# **KITTITAS COUNTY**

## **DEPARTMENT OF PUBLIC WORKS**

### **MEMORANDUM**

**TO:** All Staff  
**FROM:** Public Works Plan Review Team  
**DATE:** July 8, 2024  
**SUBJECT:** BL-24-00013 Trust for Public Land - Tom Tyner

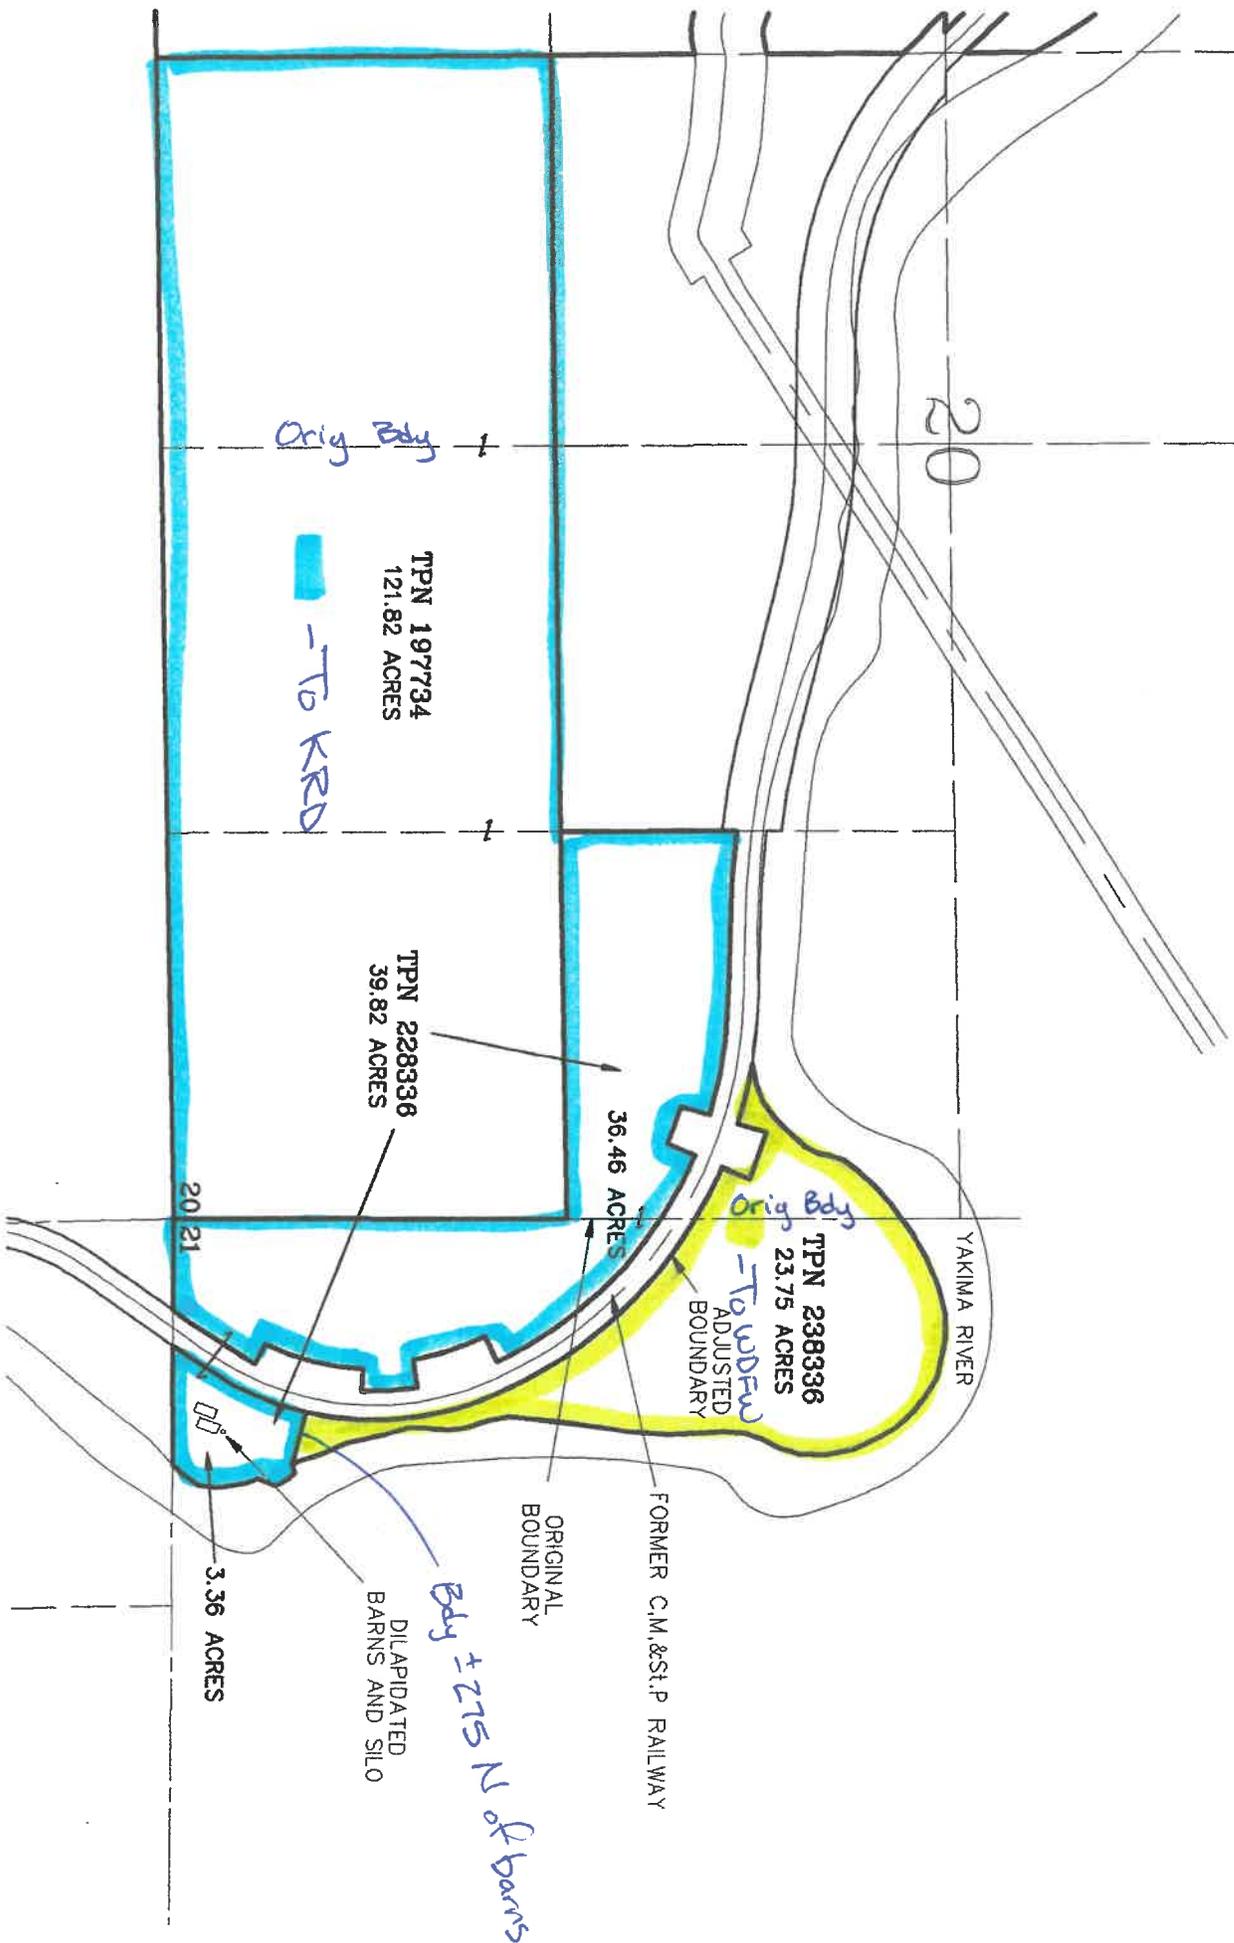
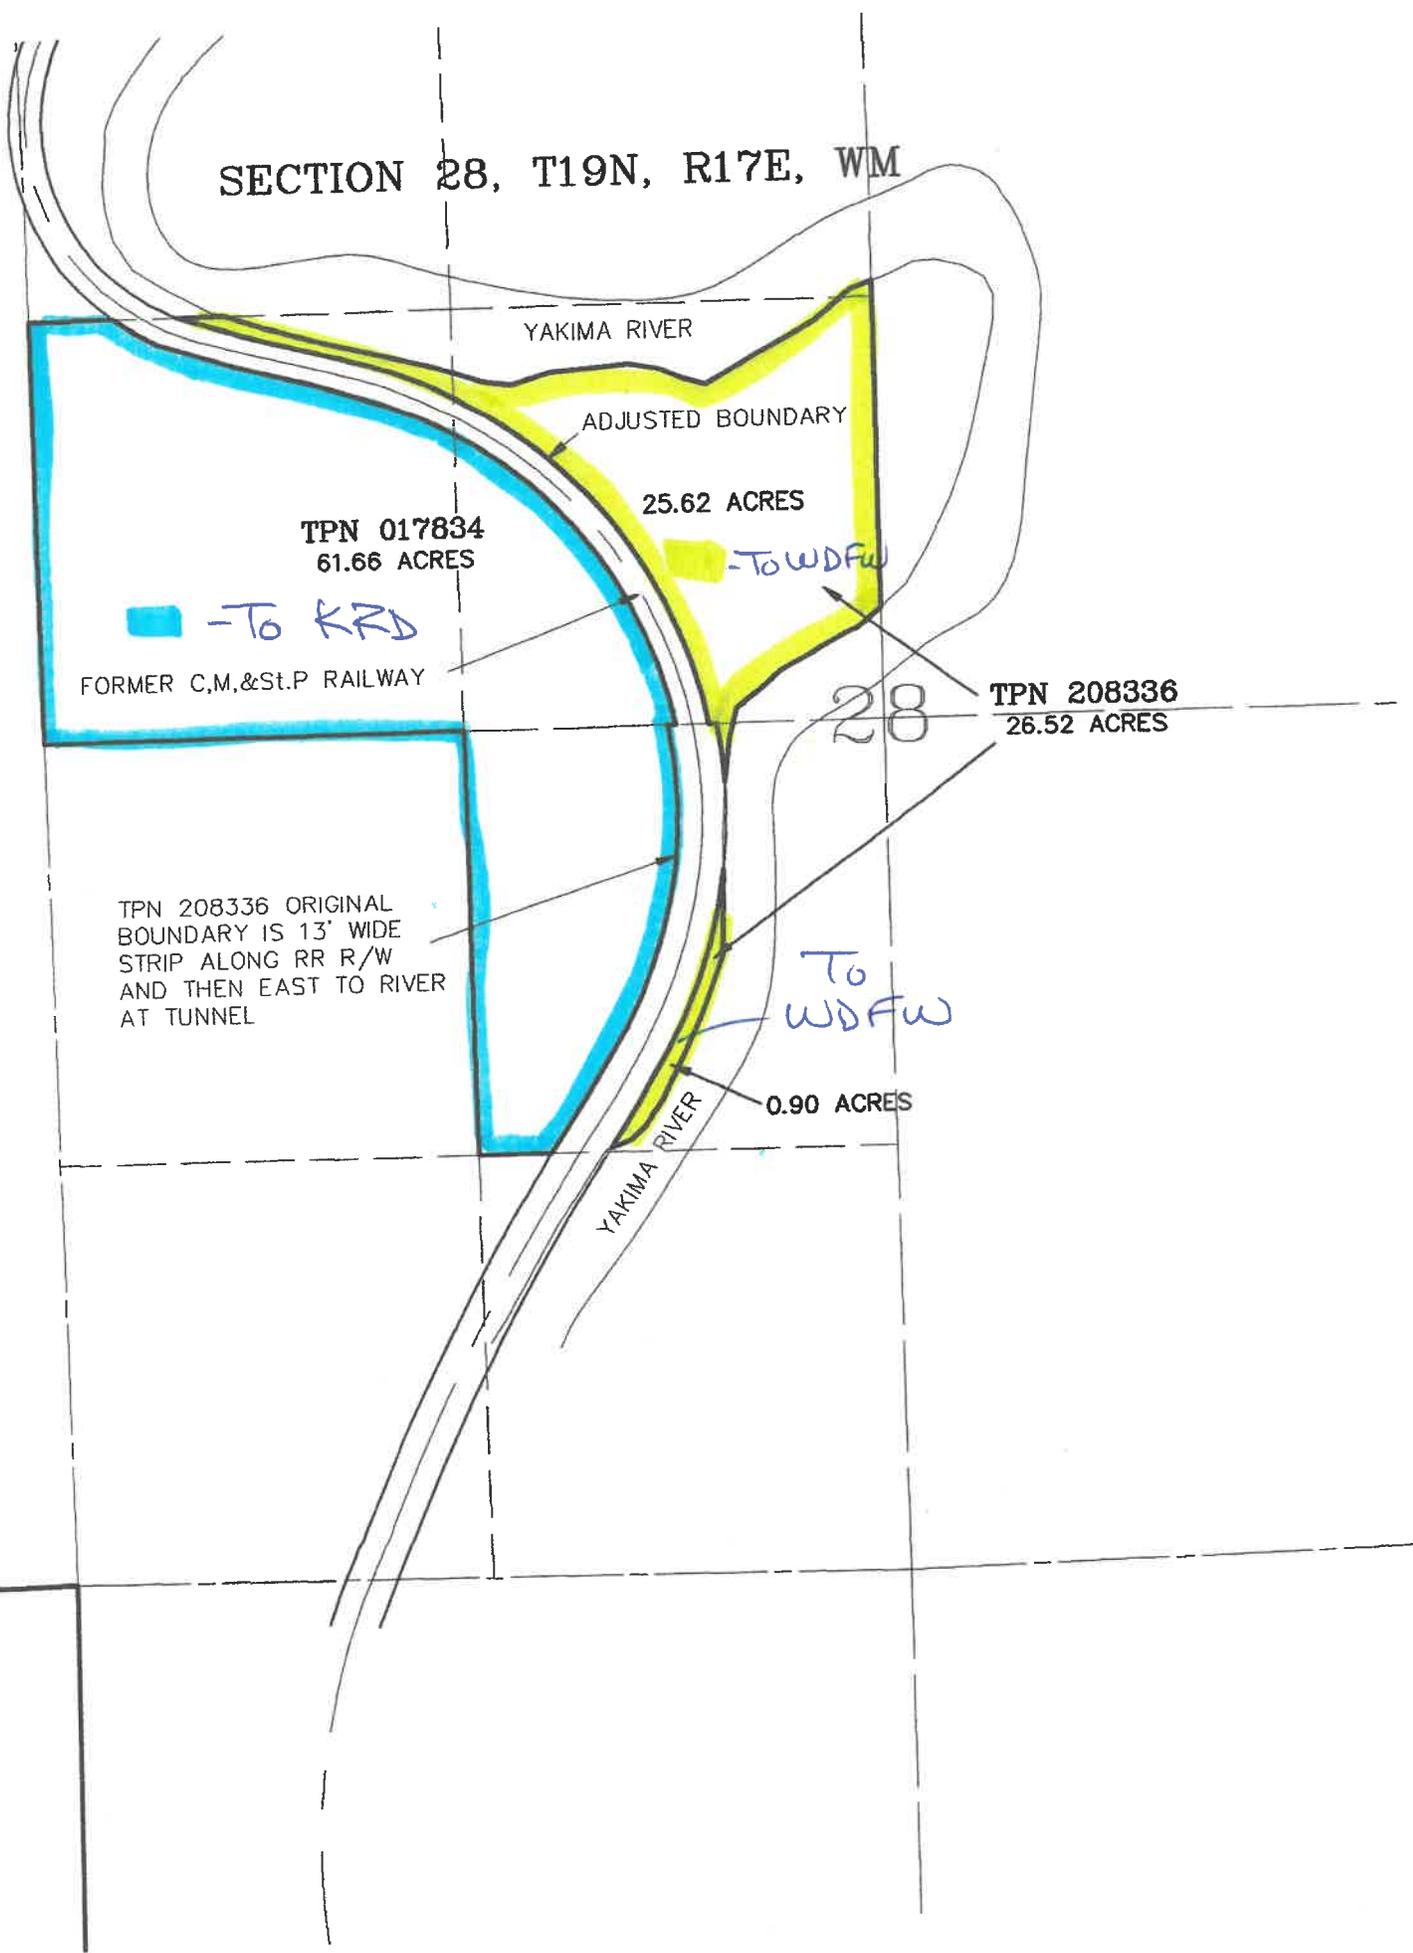
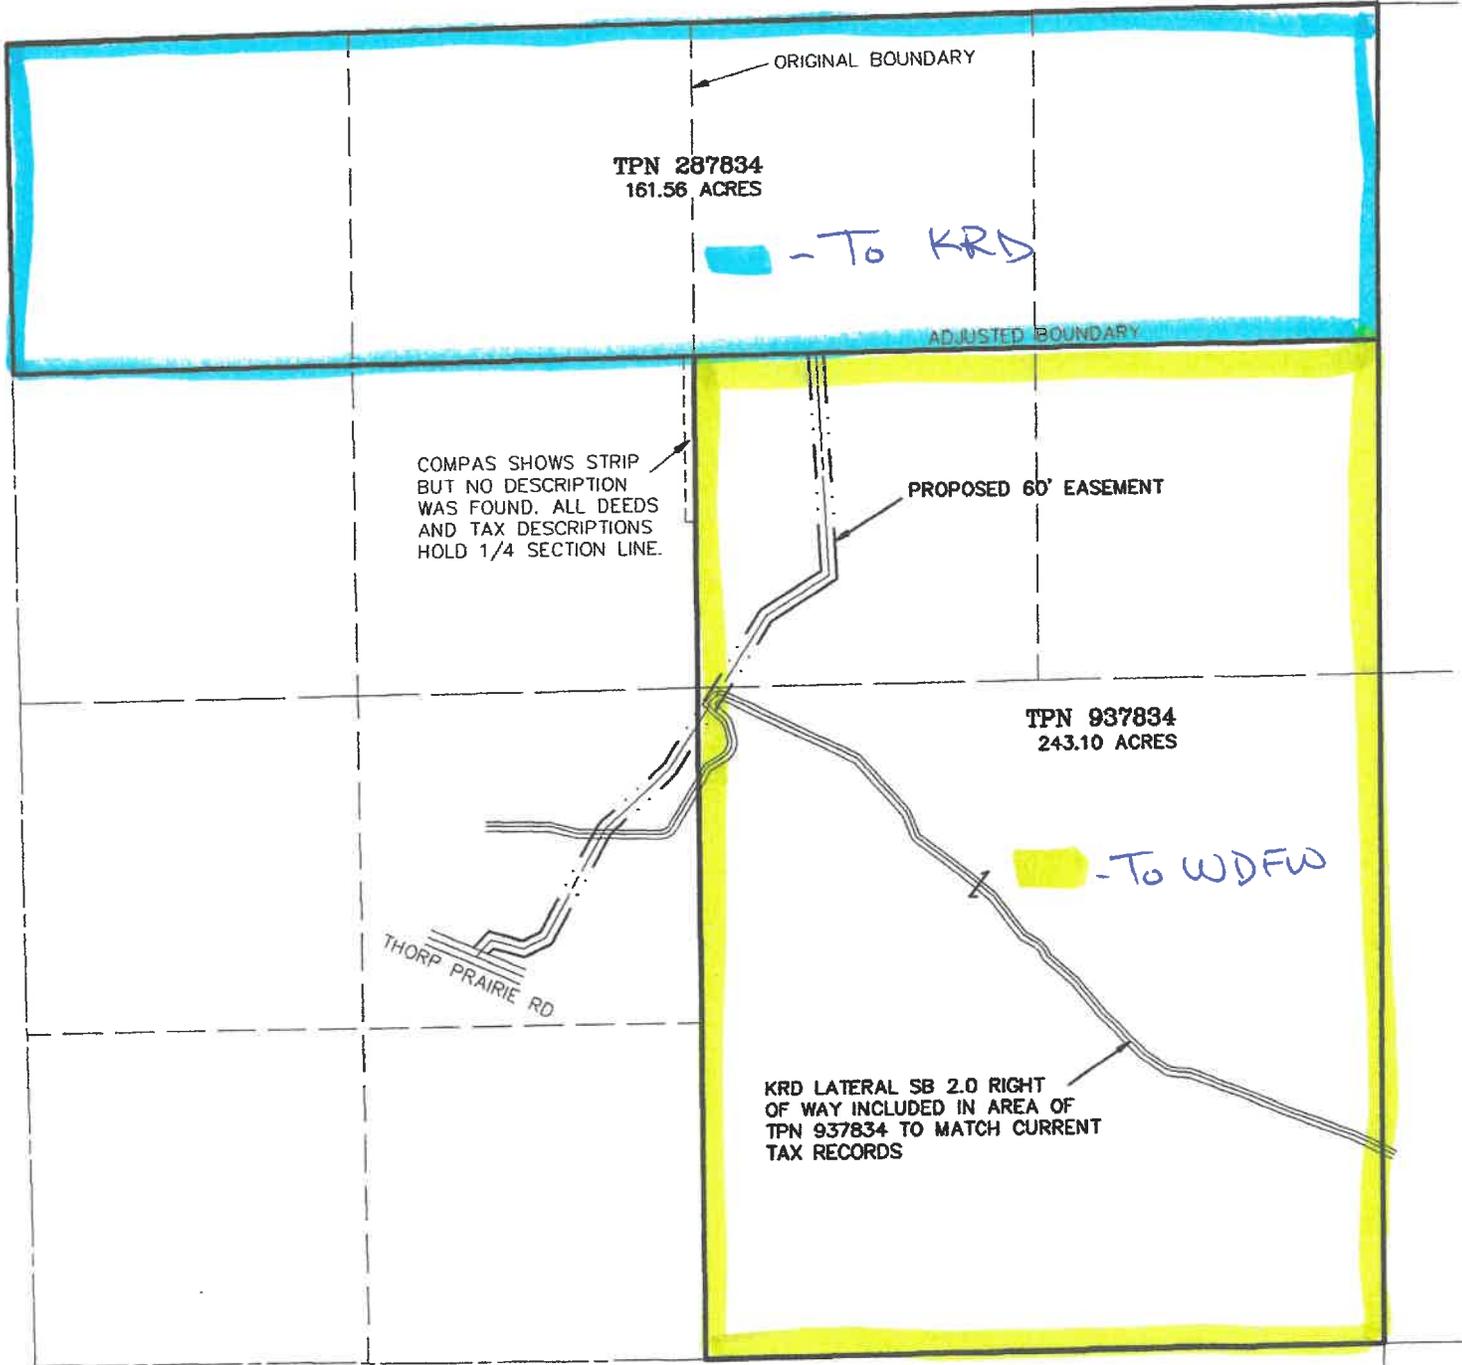
<b>SURVEY</b>	<p>As the application does not contain a survey map, comments are reserved until final. (KAH)</p> <p>UPDATE 08/13/2024</p> <ol style="list-style-type: none"><li>1. The provided title report is incorrect in that it does not describe the subject lands. As such, existing legal descriptions and property burdens have not been reviewed. This will need to be corrected and reviewed before final approval.</li><li>2. Where spirals are shown, sufficient information to recreate the spiral at centerline will need to be provided. In instances where BS, BC, EC, and ES can be used to determine spiral length, the only thing that would need to be included would be the spiral rate of change ('a' value). For offsets to c/l spiral (edge of R/W), nothing additionally is needed.</li><li>3. Please show all roadways with r/w width, ownership and surfacing. Please note Horlick Rd is missing from Sheet 2.</li><li>4. At a minimum, the new division lines will need to be staked in the field and corners shown on the face of the map. Where the new property corner is coincident with a missing section corner, a survey marker stamped in accordance with the Manual of Survey instructions shall be set.</li></ol>

<p>5. Please include language for Easement Z identifying its purpose together with “ to be created via separate document”.</p> <p>OF NOTE (no changes required) Including the Arc dimensions for the West side of Parcel E on sheet 7 would be beneficial. While this data appears on sheet 5, it is the only dimension for Parcel E occurring on that page. (JT)</p>
<b>TRANSPORTATION CONCURRENCY</b>	No transportation concurrency is required for this project. (KAH)
<b>FLOOD</b>	A portion of the parcels in this boundary line adjustment are located within the 100-year floodplain. If possible, any future development should remain outside of the floodplain in order to reduce risk and avoid mandatory flood insurance purchase requirements. All activities within the floodplain must be permitted through the floodplain development permit process and follow the regulations within KCC 14.08. (SC)
<b>WATER MITIGATION/ METERING</b>	No comments. (SC)
